RESPONSE TO REQUEST FOR INFORMATION#1

PROJECT: 3024 69TH AVE SE
DATE: 2023.05.09
PERMIT NO#: CAO22-023 (SULLIVAN CRITICAL AREA REVIEW)
OWNER: JOHN SULLIVAN

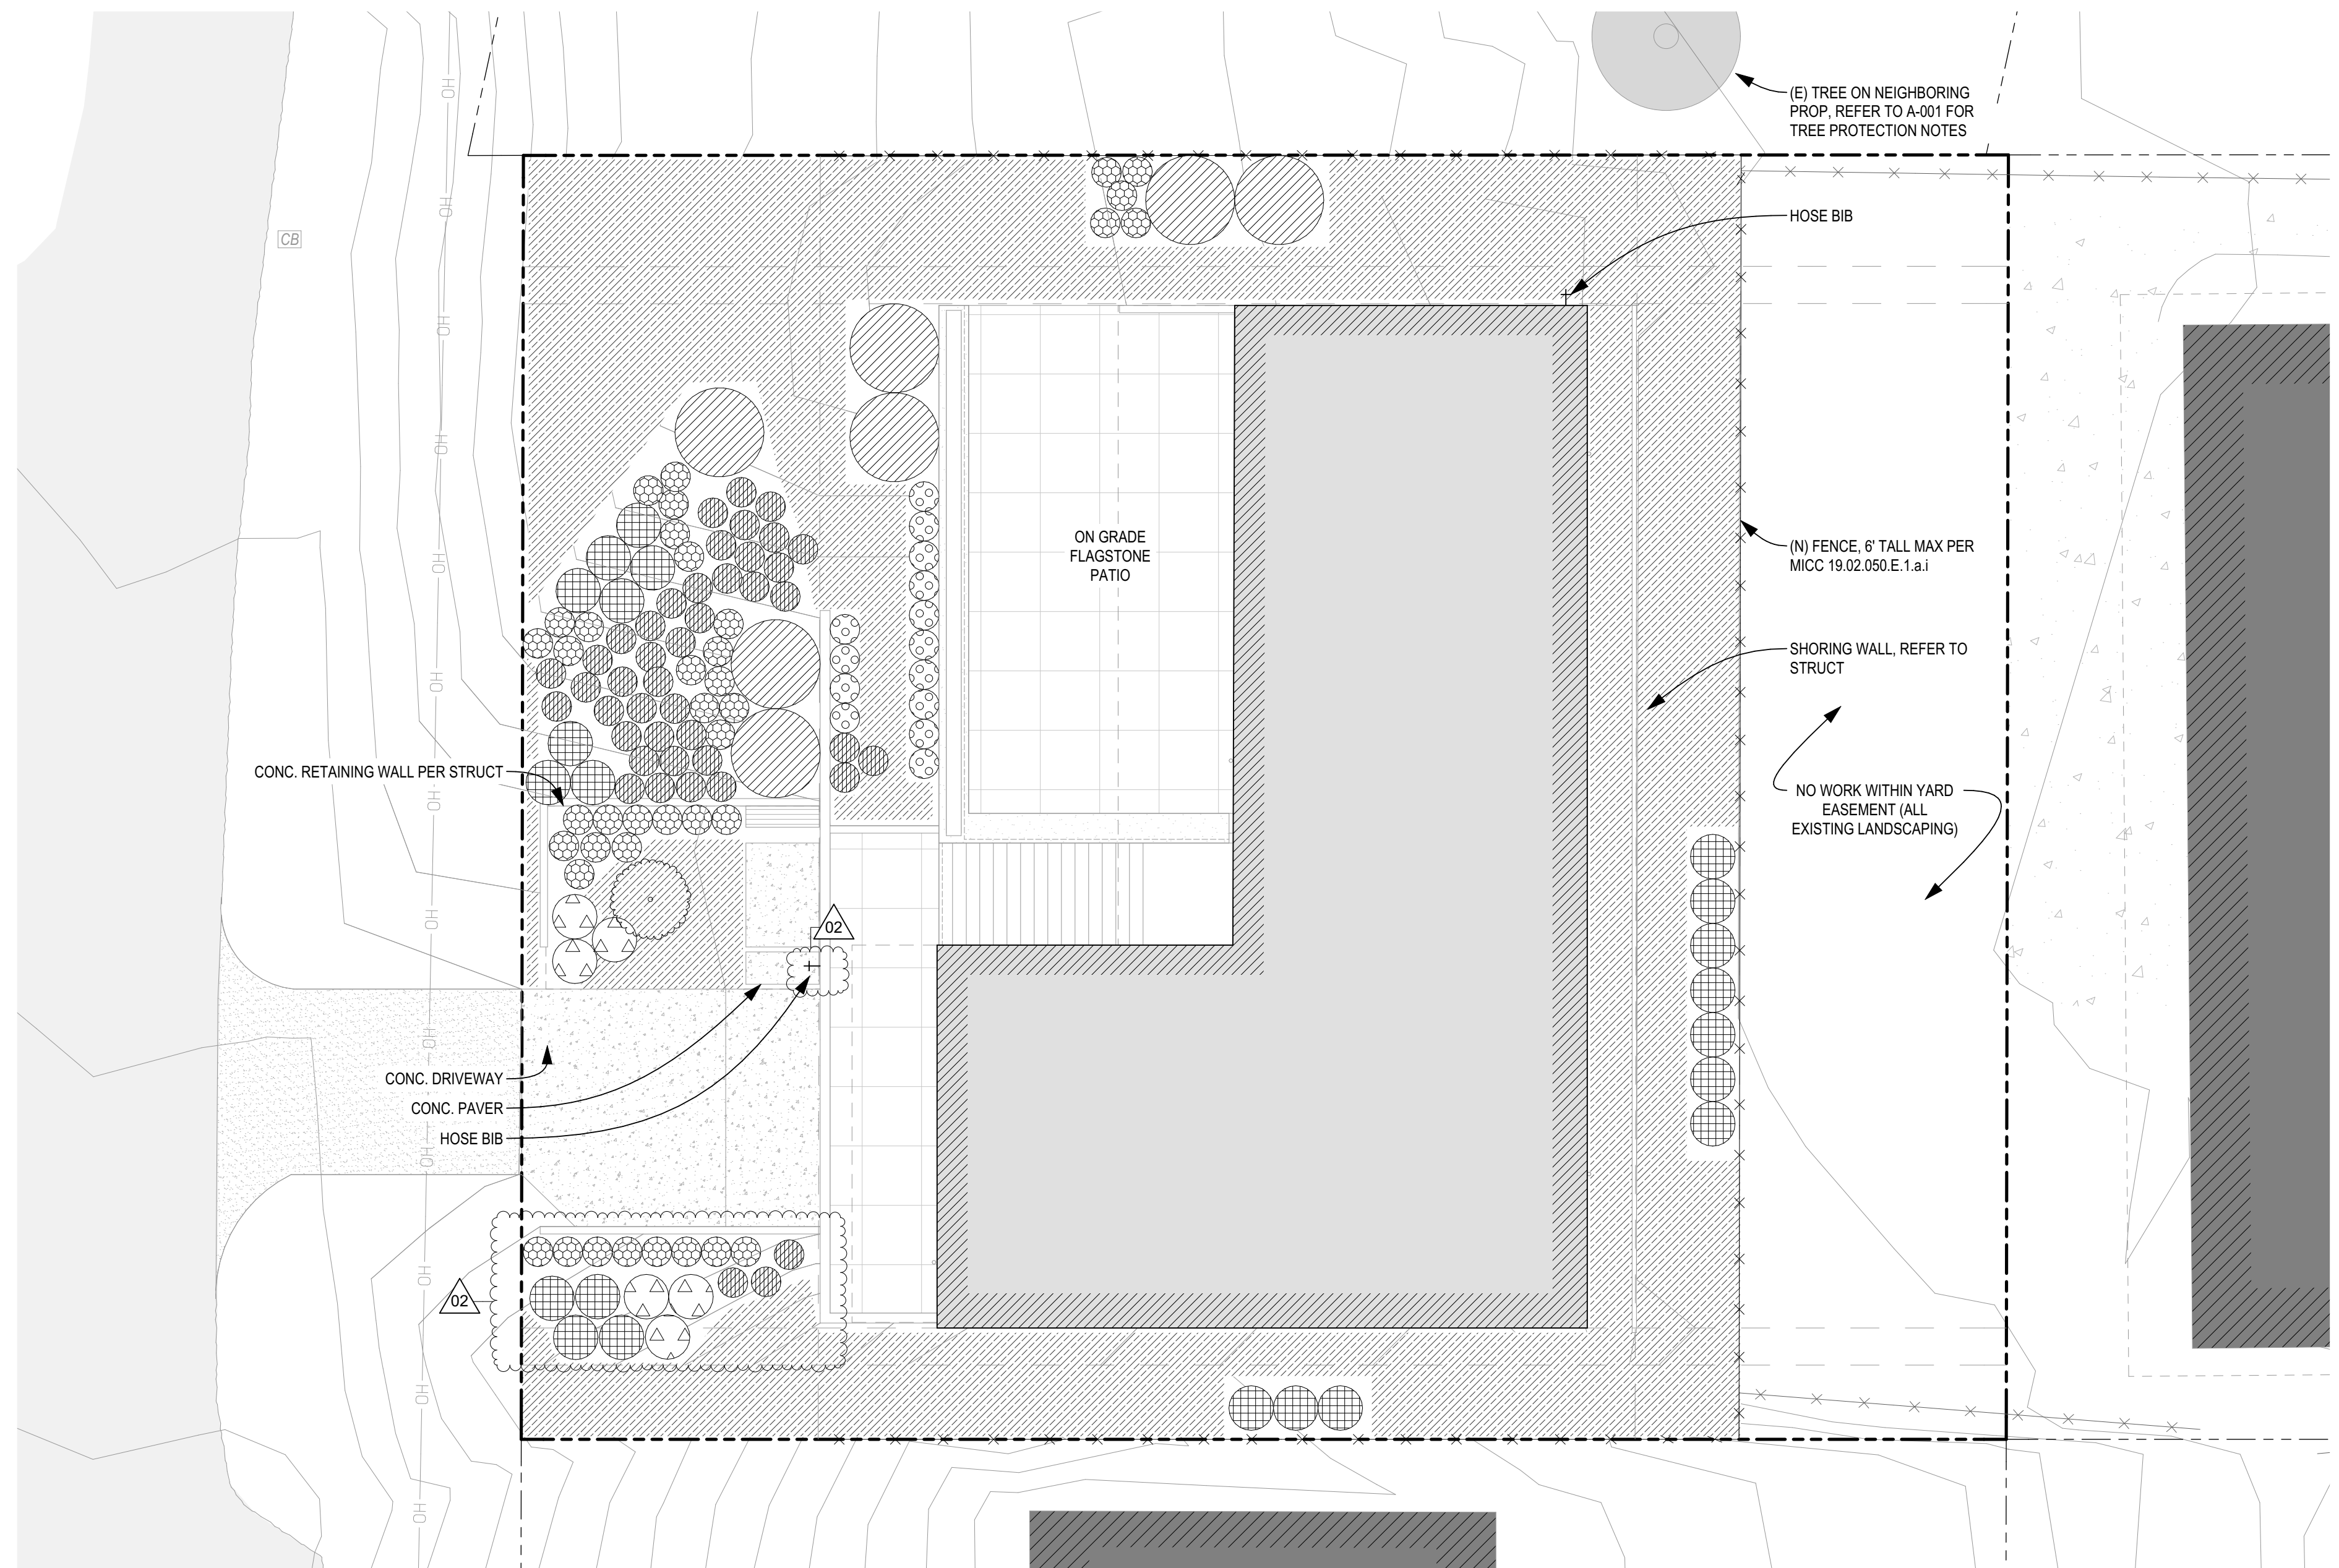
2: MICC 19.07.160(B)(2)(d) requires all disturbed areas of the geologically hazardous areas outside of building footprints to be landscaped. Please provide a landscaping plan showing how the disturbed areas of the geologically hazardous areas outside of building footprints will be landscaped.

RESPONSE: Landscape plan has been submitted as part of this revision cycle. Refer to sheet A-003 for landscape plan.
